**Town of Addison
Summary of Engineering Revision Comments**

Development: Galaxy FBO

Town Project #:19-09D

SHEET NUMBER
C08.01

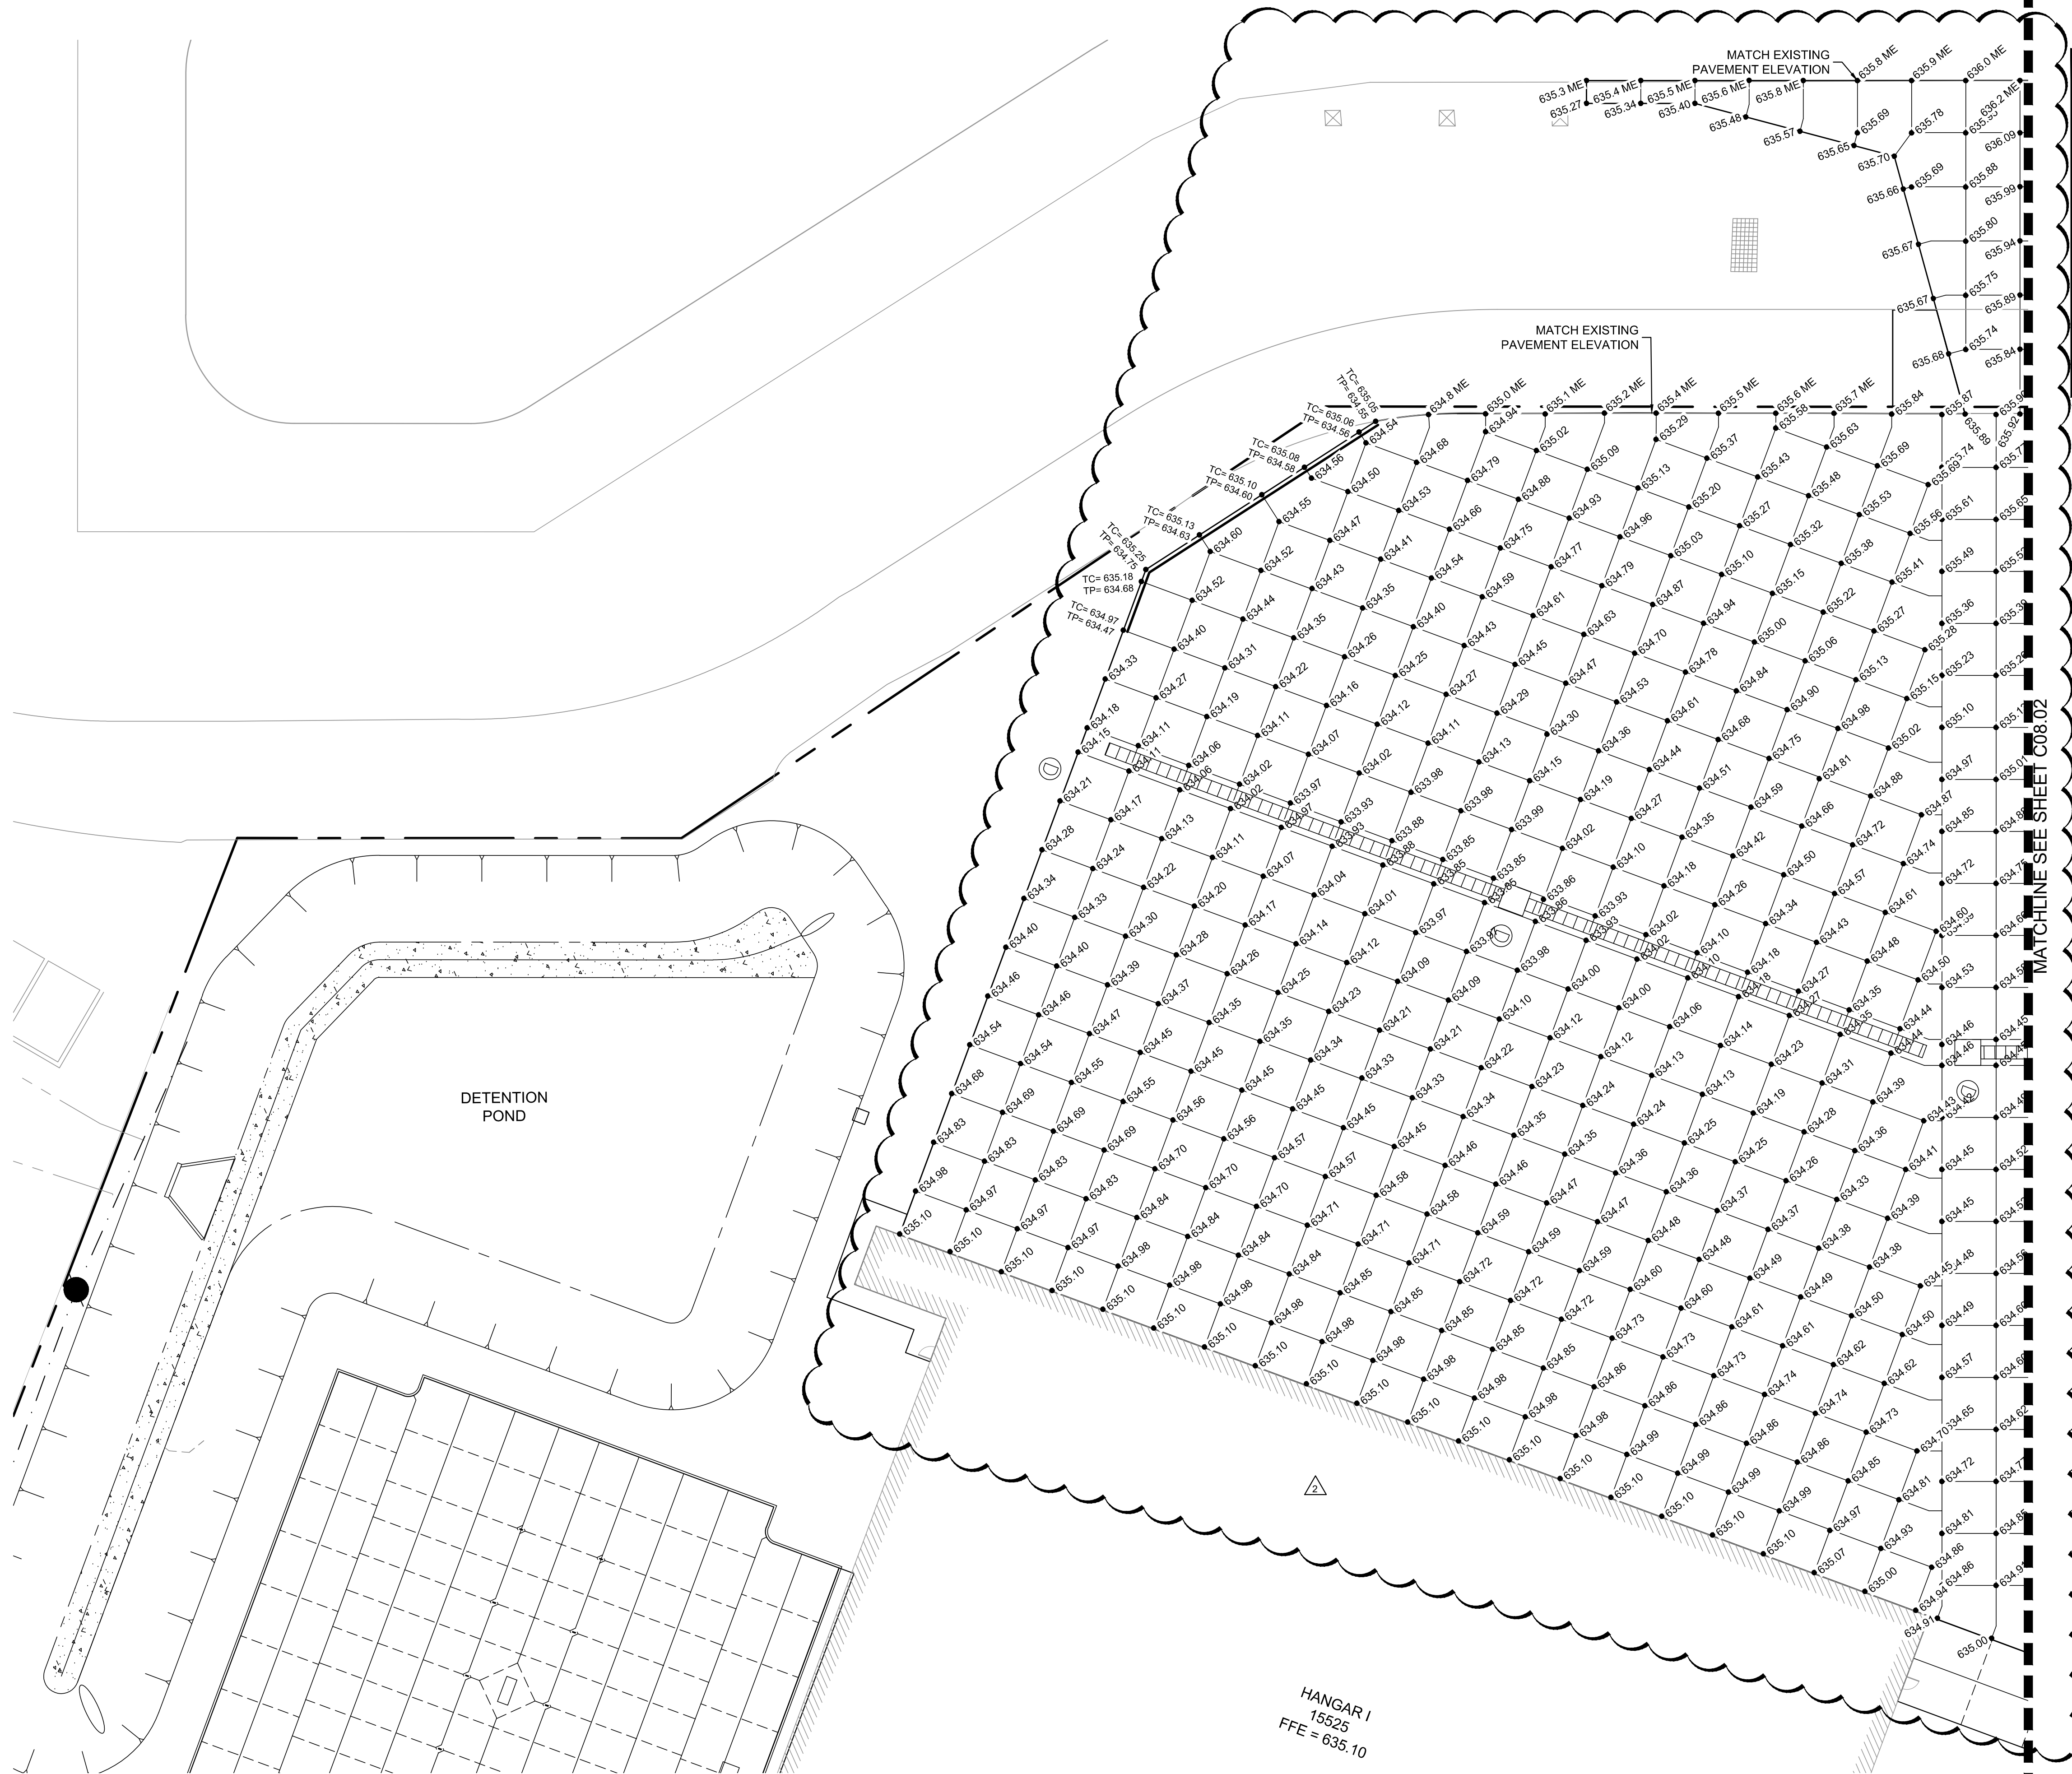
ASI-C006	10/30/2020	C08.01	Updated grading per field conditions verified by a construction progress topographic survey.	
ASI-C006	10/30/2020	C08.02	Updated grading per field conditions verified by a construction progress topographic survey.	
ASI-C006	10/30/2020	C08.03	Updated grading per field conditions verified by a construction progress topographic survey.	
ASI-C006	10/30/2020	C09.01	Updated grading per field conditions verified by a construction progress topographic survey.	
ASI-C006	10/30/2020	C09.02	Updated grading per field conditions verified by a construction progress topographic survey.	
ASI-C006	10/30/2020	C09.03	Updated grading per field conditions verified by a construction progress topographic survey.	
ASI-C006	10/30/2020	C10.02	Updated grading per field conditions verified by a construction progress topographic survey.	
ASI-C006	10/30/2020	C10.03	Updated grading per field conditions verified by a construction progress topographic survey.

SHEET NUMBER
C10.05

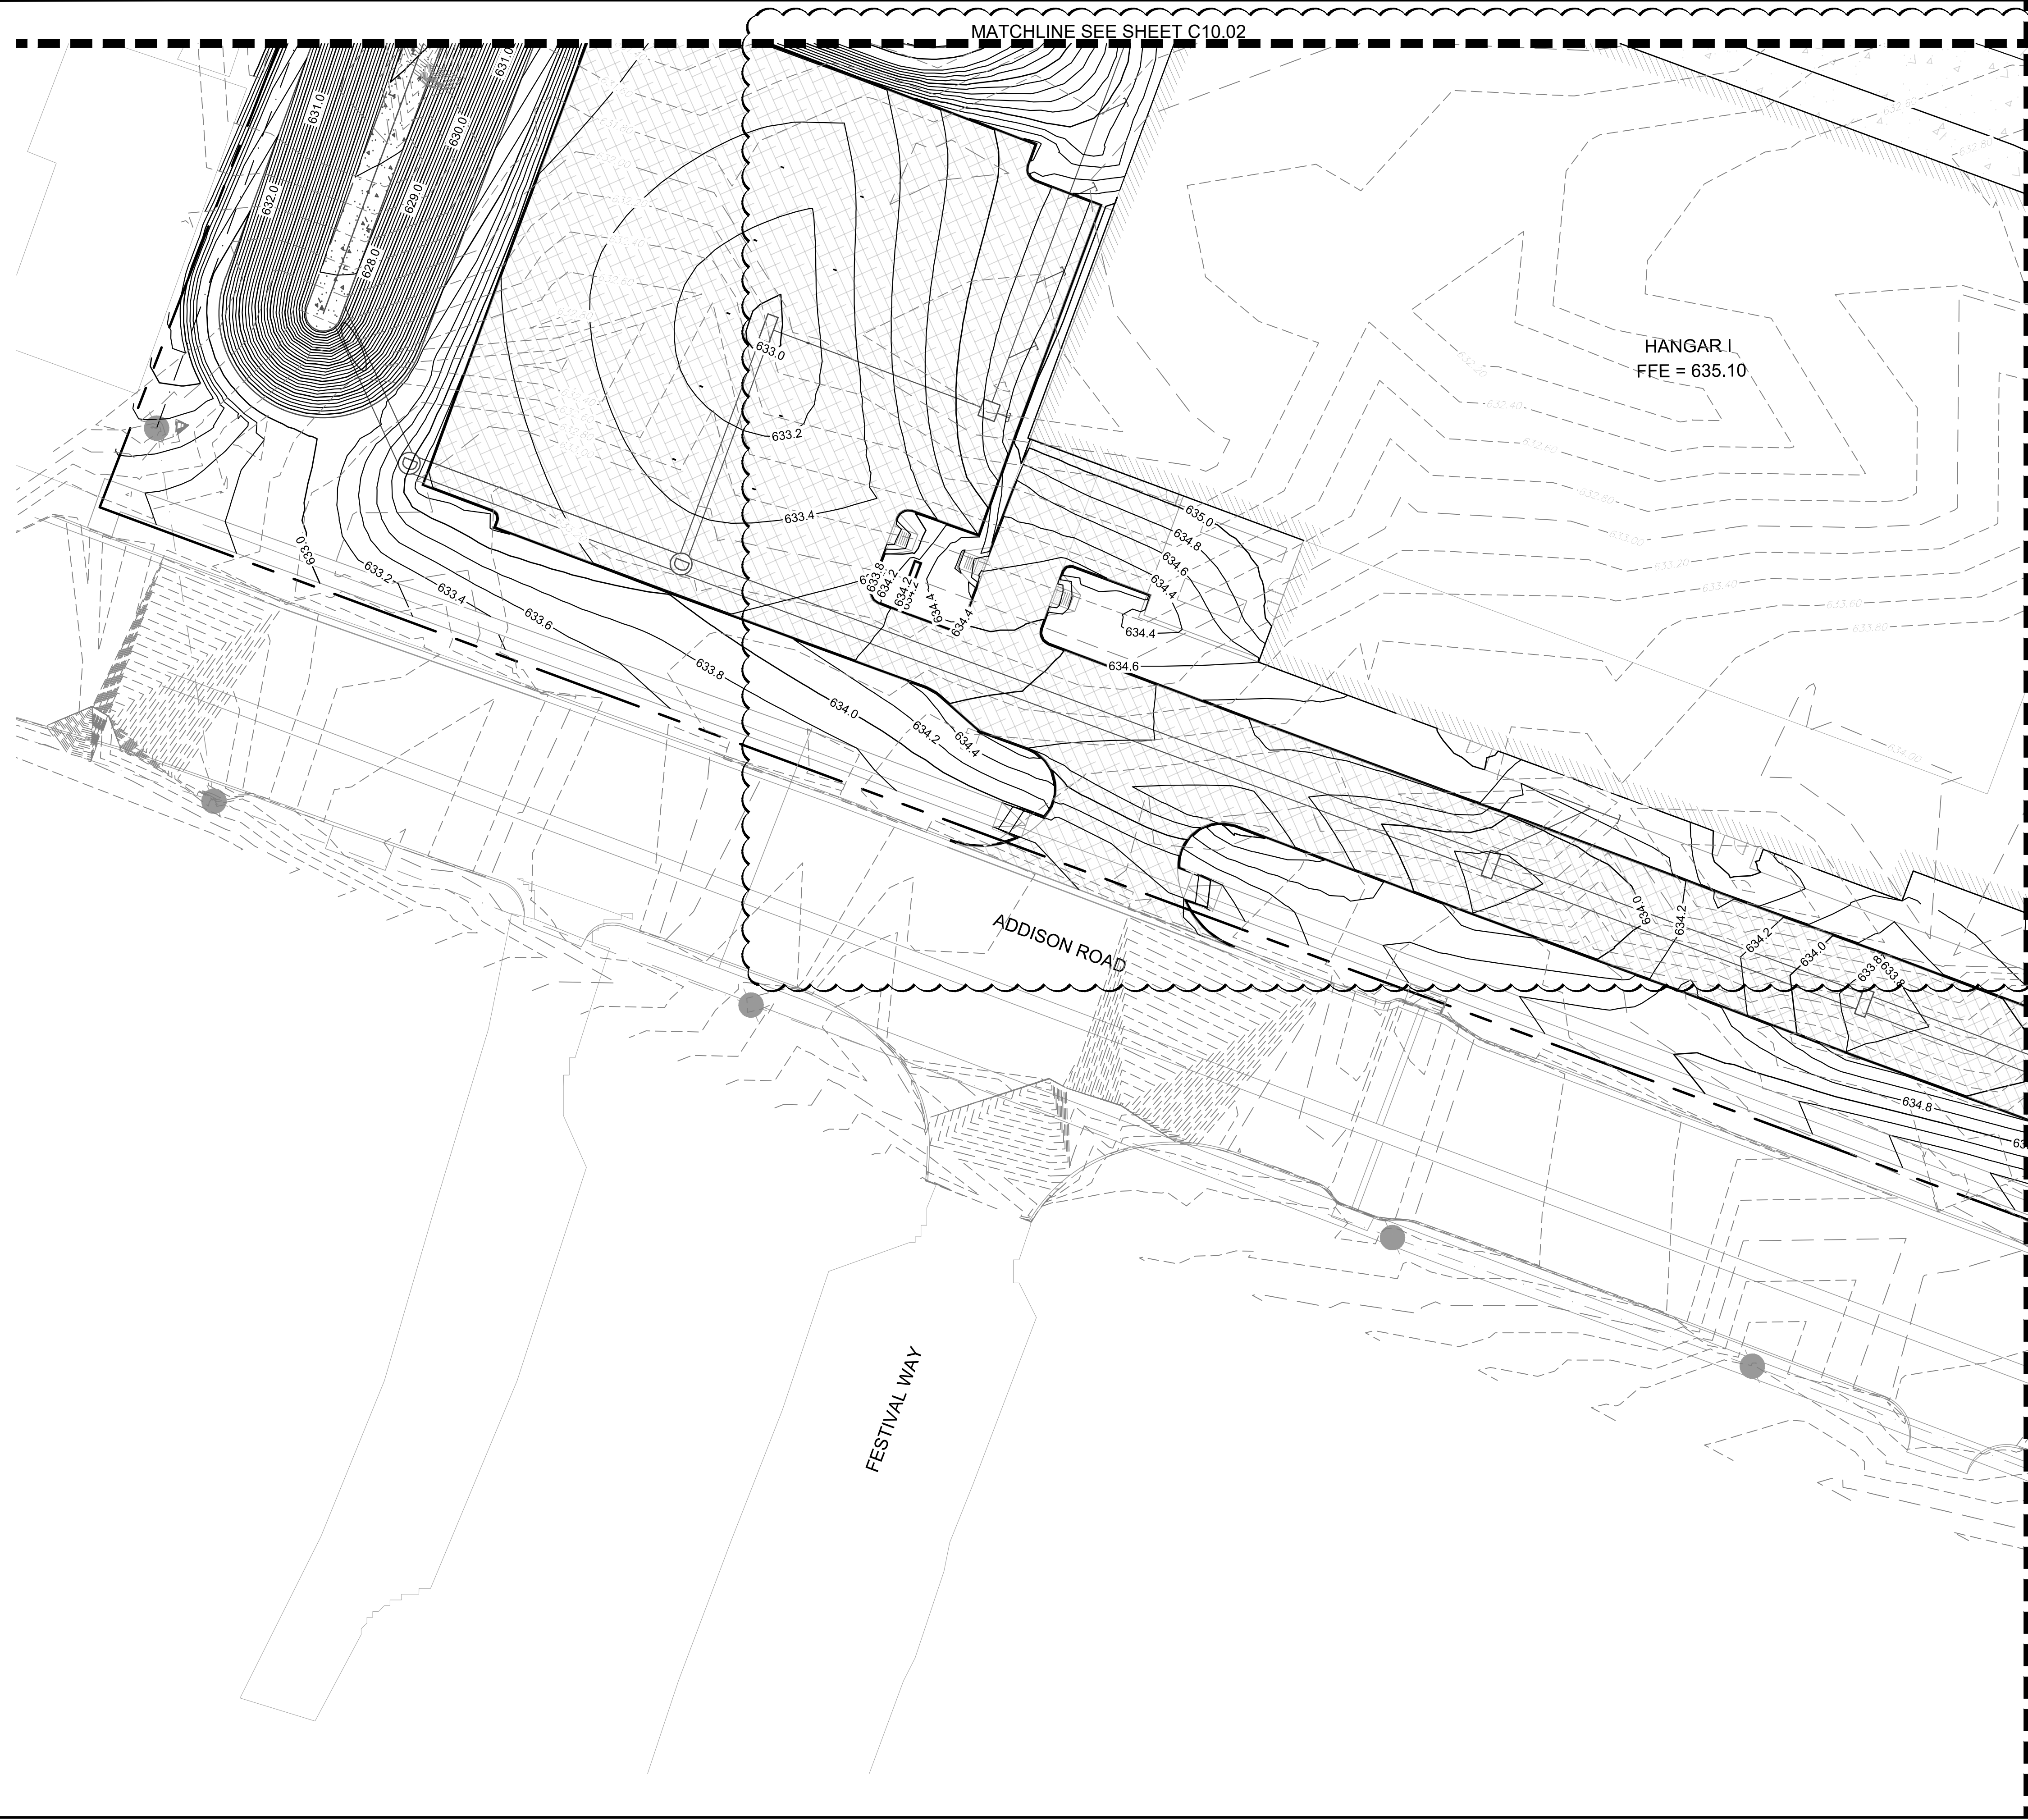
ASI-C006	10/30/2020	C10.04	Updated grading per field conditions verified by a construction progress topographic survey.	
ASI-C006	10/30/2020	C10.05	Updated grading per field conditions verified by a construction progress topographic survey.	
ASI-C006	10/30/2020	C10.06	Updated grading per field conditions verified by a construction progress topographic survey.	
ASI-C006	10/30/2020	C10.07	Updated grading per field conditions verified by a construction progress topographic survey.	
ASI-C006	10/30/2020	C10.08	Updated grading per field conditions verified by a construction progress topographic survey.	
ASI-C006	10/30/2020	C12.02	Updated rim and top of grate elevations on storm structures per field conditions verified by a construction progress topographic survey.	
ASI-C006	10/30/2020	C12.03	Updated rim and top of grate elevations on storm structures per field conditions verified by a construction progress topographic survey.
